Our Ref: R/2018/3/C
File No: 2020/354403
Your Ref: SSD - 9194

Andy Nixey
Principal Planner – Key Sites Assessment
Department of Planning, Industry and Environment

**Additional Response to Submissions – Student Accommodation (SSD 9194)
13-23 Gibbons Street, Redfern**

2 Street Elevation_Margaret Street
1 : 500

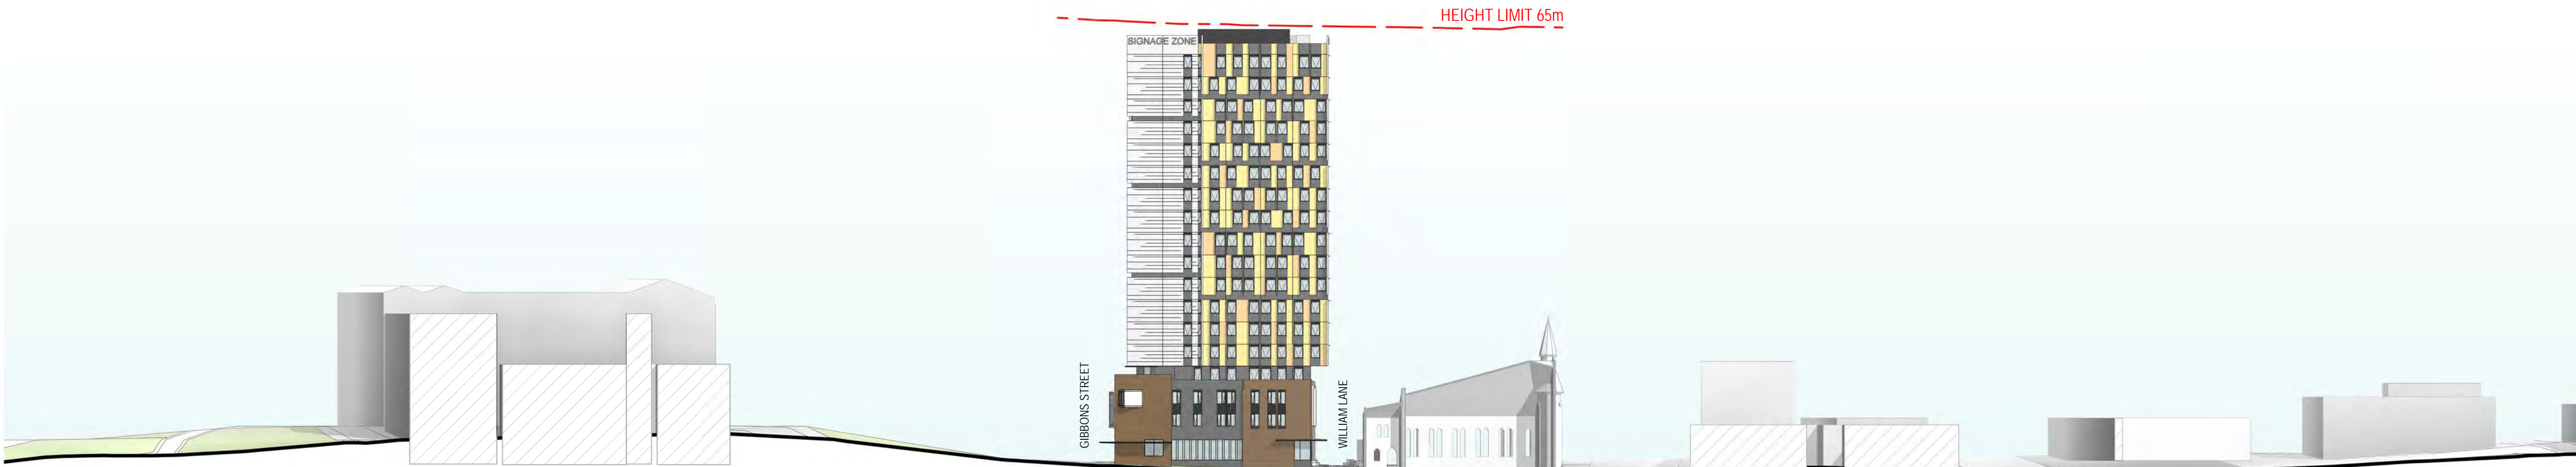
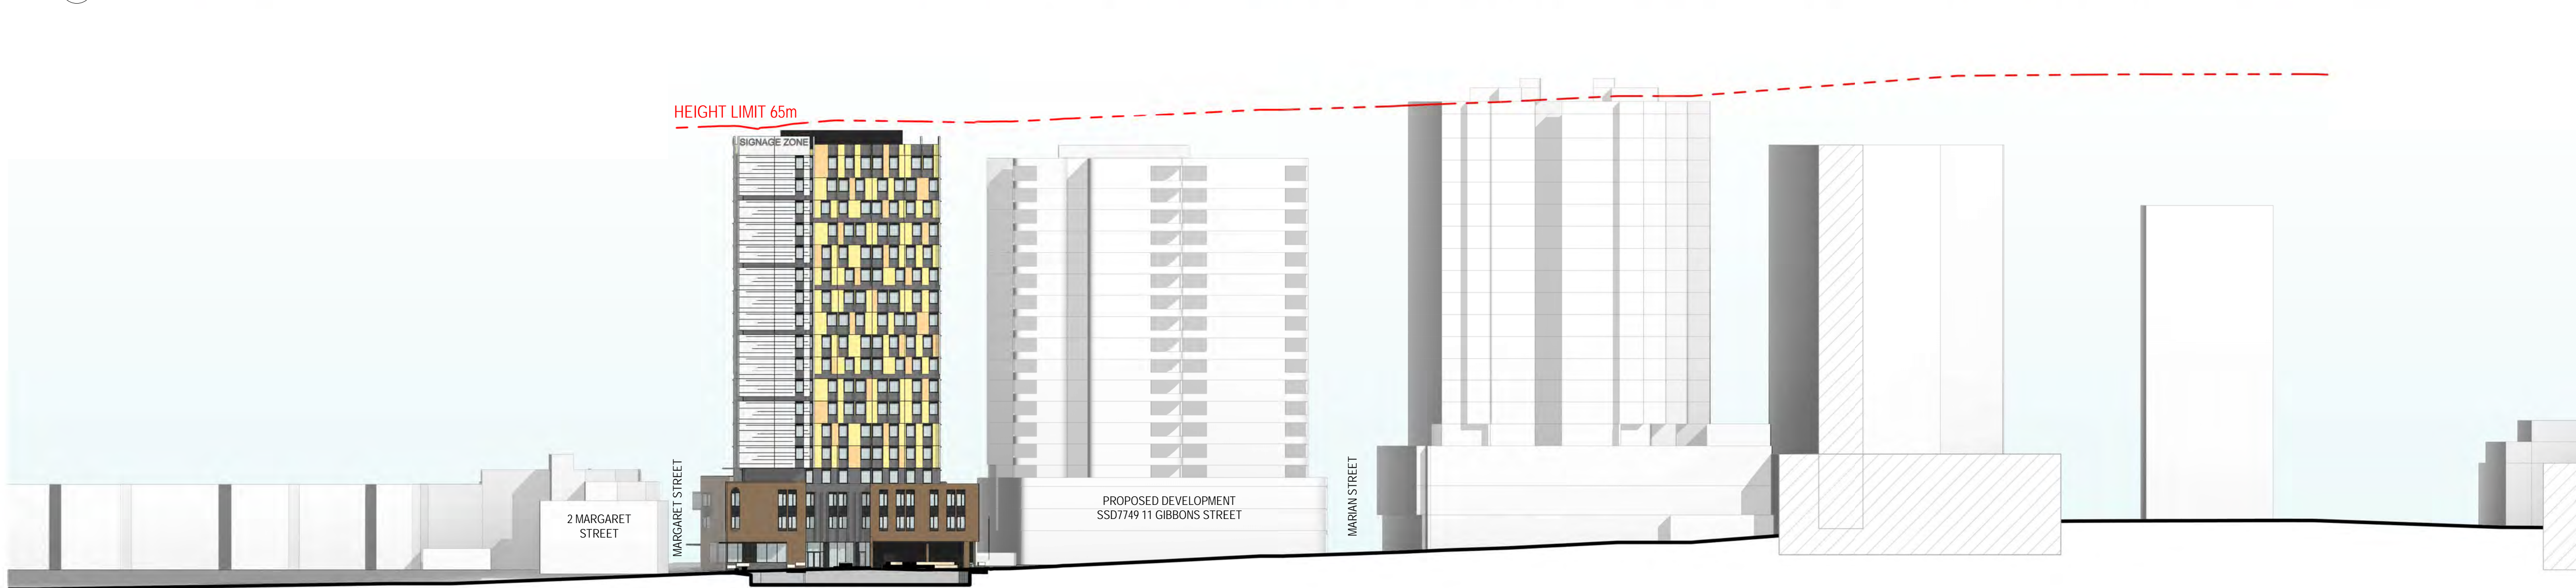
However, it is considered that further improvements can be made to the ground floor to enhance the building expression and passive surveillance of the development. Specifically, the City recommends that the ground floor elevation along Margaret Street reduce the density of screening and employ other methods of privacy such as fritted or translucent glass. The excessive number of screens defeats the purpose of passive surveillance and does not positively address the street and further encourage an active frontage.
